Our Case Number: ABP-318758-23

Re: Proposed public realm improvement works known as the "Westgate 2040 Project"
in Drogheda, County Louth

Westgate 2040 Regeneration

Submission by Drogheda Cycling Group

DRAWING
Section T-T
Father Connolly Way

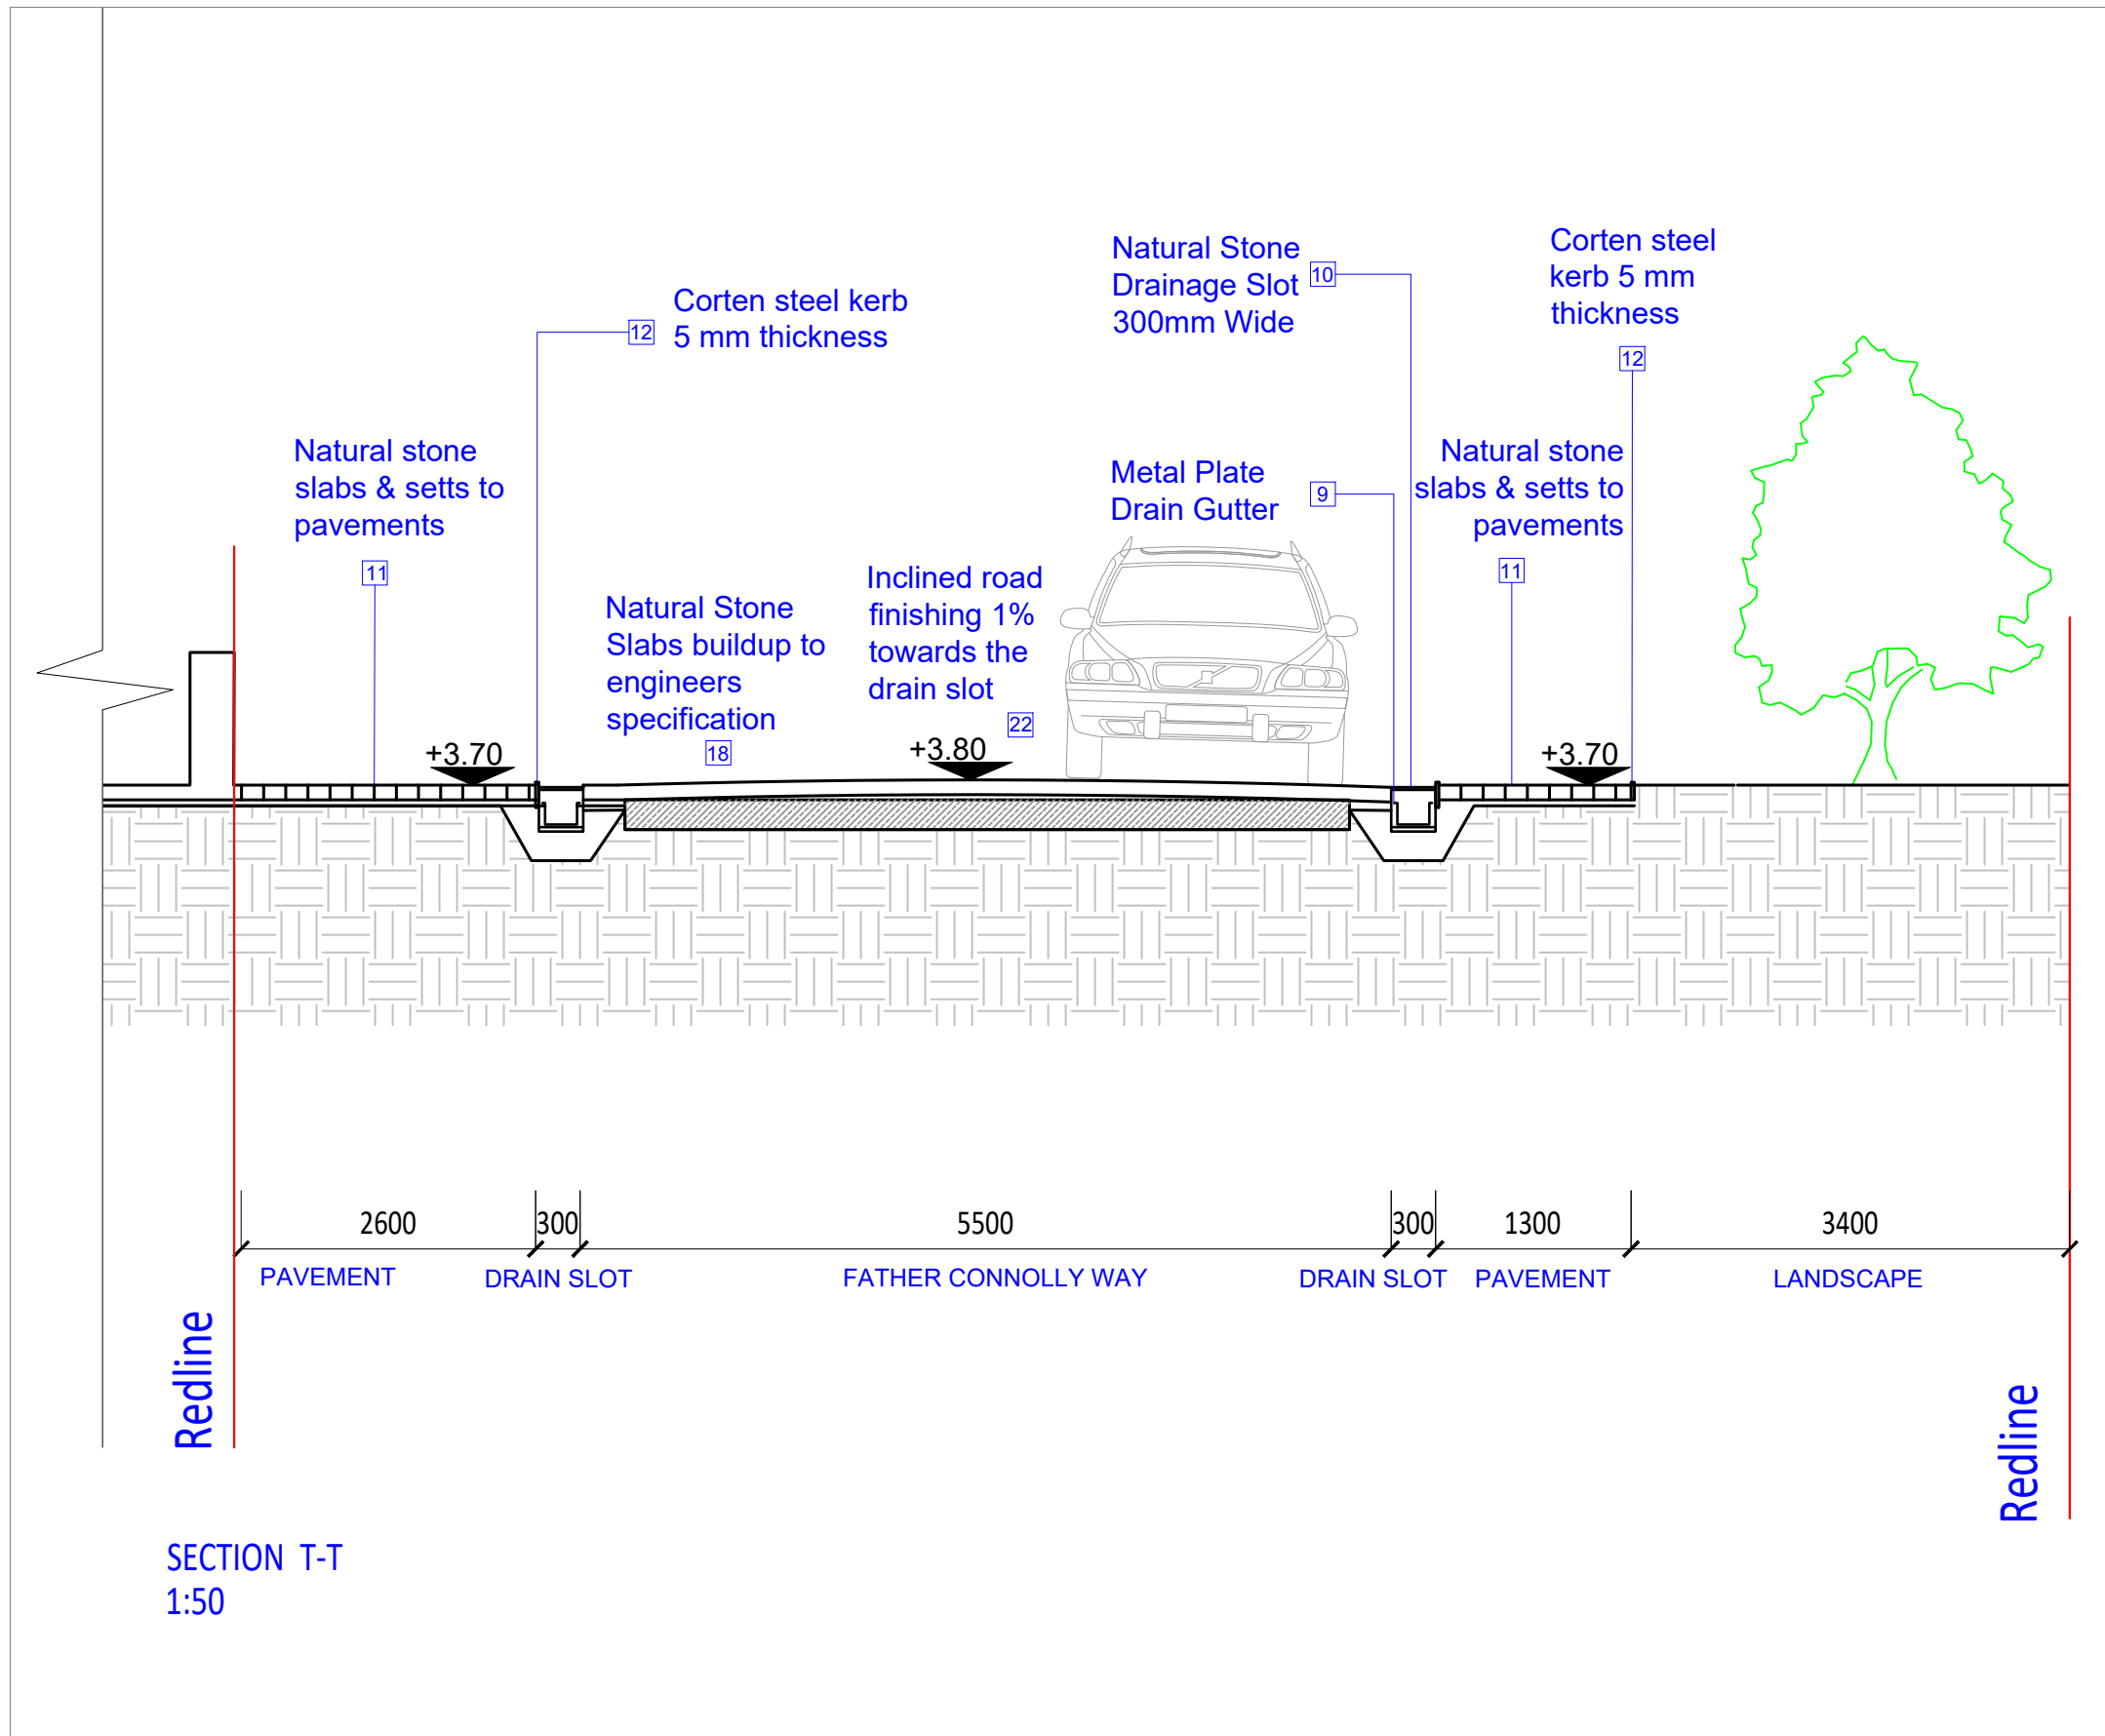
We note and welcome that the plan includes provision for an additional 36 Cycle Parking Stands with capacity to accommodate approx. 72 no. parked bicycles. However, the proposed location, Figure 1 (opposite Barlow House) does not connect to the proposed two-way Bicycle Lane on Father Connolly Way and, in that way, fails to offer further connection to the existing Boyne Greenway accessed across Dominics bridge adjacent to Father Connolly Way. We would ask that consideration be given to adding a number (TBD) of Cycle Parking Stands in the Car Park area to front of Courthouse and adjacent to the Bicycle Lane on Father Connolly Way. We also note that the Road Safety Audit suggests, from the design proposals, that provision for wayfinding and safe unobstructed access to and from these spaces is not clear, as many of the spaces are located adjacent to narrow footways, where there is insufficient space for cyclists to walk alongside pedestrians, and no provision for suitable kerb transitions/dropped kerbs to facilitate transfer from off road to on road facilities

It is critical that the Westgate 2040 regeneration is not a missed opportunity to connect the new public realm to this Boyne Greenway. Existing cycle routes are laid out in Figure 4. Drogheda Cycling Group is asking that the final plan ensures a continuous, free flowing, safe and accessible cycle route
